Re: 31 Fore Street BP# 2016600916

*Jean Fraser, Planner
City of Portland
874 8728*

DRAWING NAME: **LANDSCAPE PLAN**
 PROJECT NAME: **31 FORE STREET REDEVELOPMENT**
 CLIENT: **PENINSULA PROPERTY DEVELOPMENT, LLC.**
 59 MOODY STREET, PORTLAND MAINE 04101

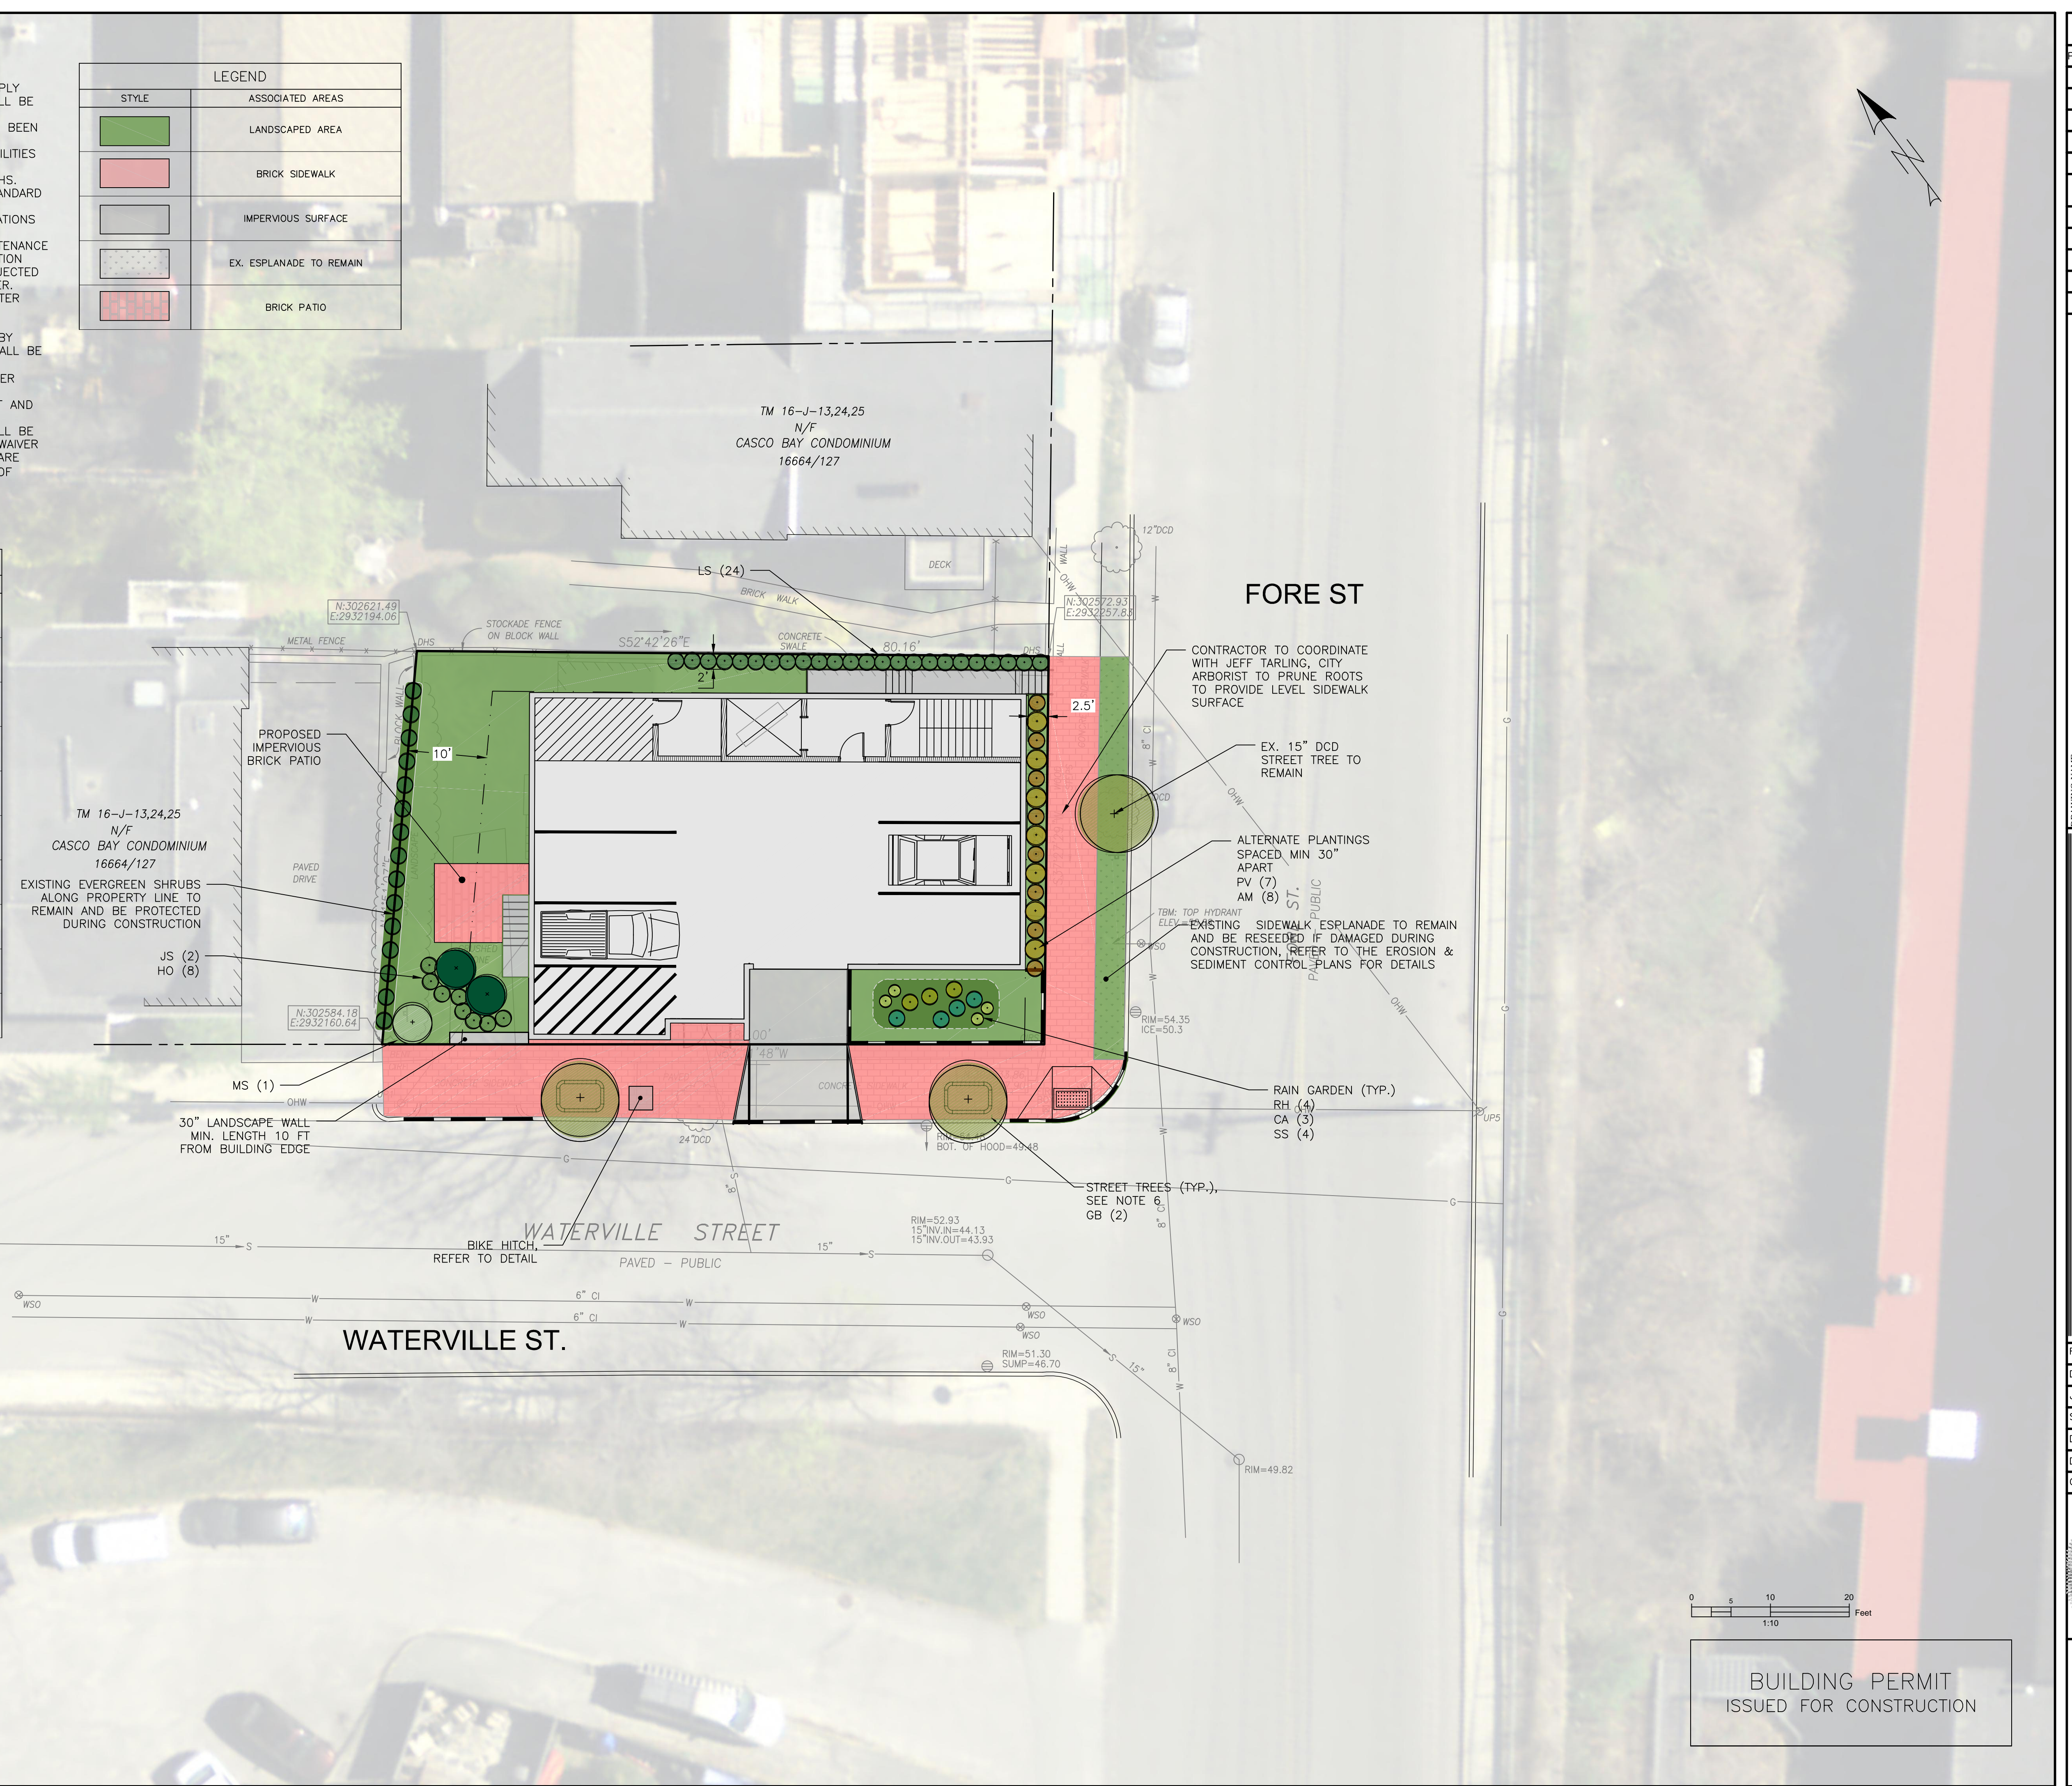
2. **Street Tree:** I am waiting for Jeff Tarling, City Arborist, to sign off on this (again, I

think it will be OK).
